Ms Karen Jones
Director Infrastructure Projects
NSW Planning and Infrastructure
GPO Box 39 , Sydney NSW 2001

**CBD AND SOUTH EAST LIGHT RAIL PROJECT
SUBMISSIONS REPORT & PREFERRED
INFRASTRUCTURE REPORT**

**Randwick City Council Response
28 March 2014**

Appendix B.6 Alison Road Indicative Staging Plan

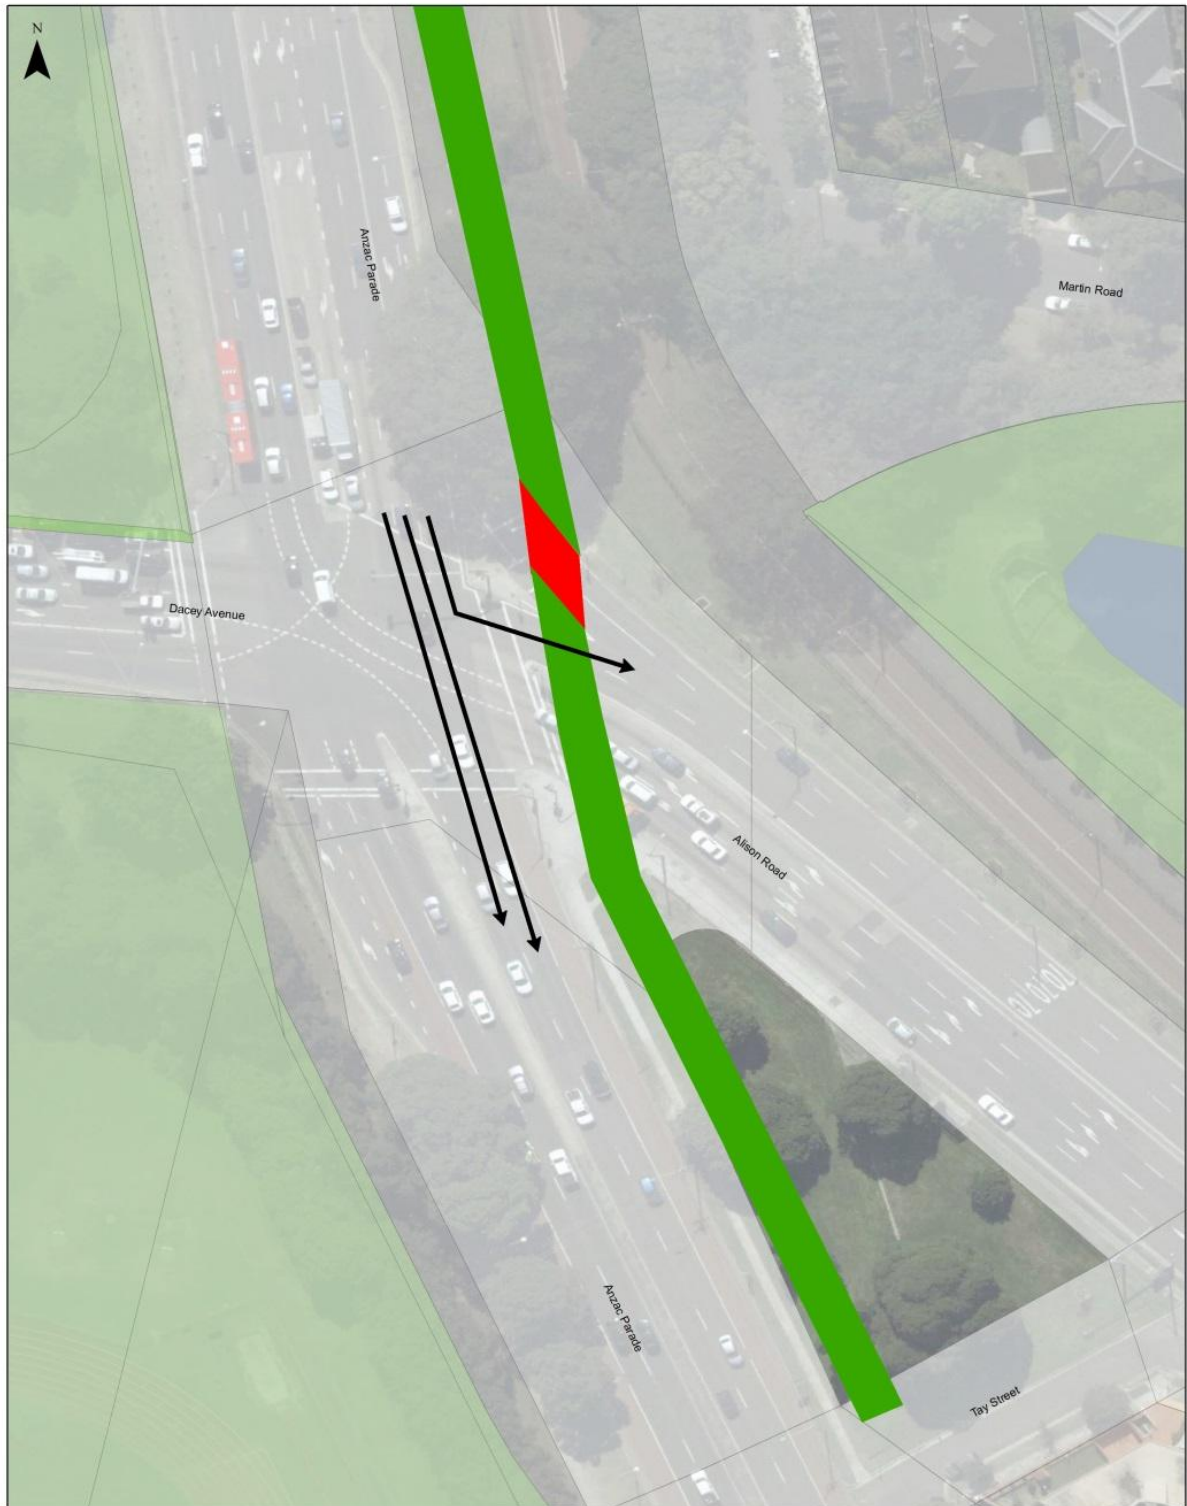
Concern is raised about the safety and design of the Prince Street/Alison Road intersection, especially with regard to pedestrian movements.

The horizontal alignment of the relocated Alison Road/Wansey Road stop is to be reconfigured so that it stays, as best as possible, within the existing road reserve.

Ensure that pedestrian signal facilities are provided on all 4 sides of the new signalised intersection at Alison Road/Wansey Road/Prince Street. The proposed slip lane from Prince Street to Alison Road (southbound) should not be provided (motorists turning left from Prince Street to Alison Road can do so through the signalised intersection – thus improving pedestrian safety).

Figure 7-17: Kingsford Precinct Access Plan

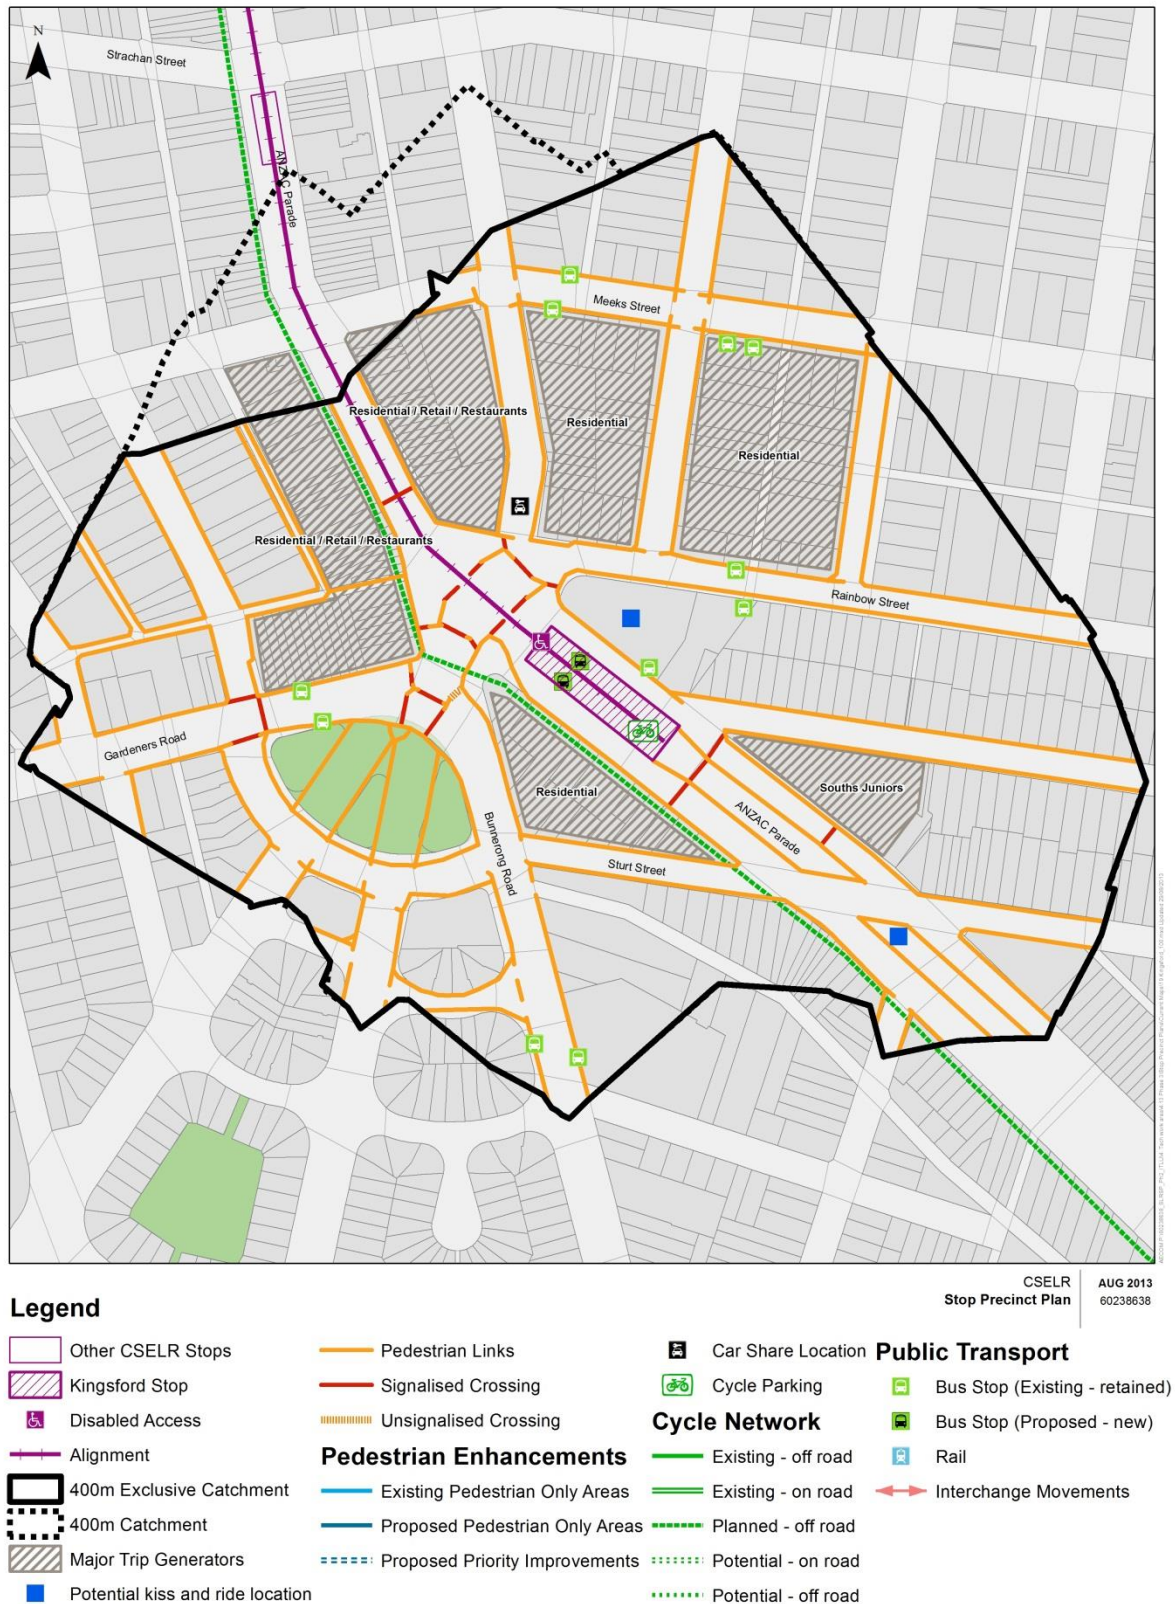
Introduction of the Kingsford Interchange will involve loss of existing car parking spaces within the Anzac Parade median between the intersection known as the 'Nine-Ways' Intersection and Sturt Street. To address this loss of parking, TfNSW is to provide a temporary car park at the southern end of the Kingsford Interchange to the south of the existing car park which currently exists to the south of Sturt Street as per the Randwick City Council Urban Design Guidelines Volume 1, Section 3 Study Area 16 Kingsford - Anzac Parade, Parking Area South of Interchange. See also Council's recommended condition in this regard.

Council is still concerned about pedestrian safety at this location and questions how pedestrians can safely access the platforms from the either side of Anzac Parade. There are also safety concerns regarding the likely behaviour of pedestrians if they are delayed, by multiple phases, as they cross the full width of Anzac Parade. This needs to be further investigated as part of the review of the overall detailed design of the Kingsford Interchange.

Council maintains its position that separating the interchange from the complex Nine-Ways intersection would be a simpler arrangement for motorists and pedestrians, which involves less loss of parking opposite the South Juniors. Council would prefer the option of extending the light rail to Maroubra Junction, or as a minimum, relocating the interchange further to the south near Botany Street. It is requested that the Kingsford Interchange be appropriately designed to allow for potential future extension of the light rail system to Maroubra Junction.
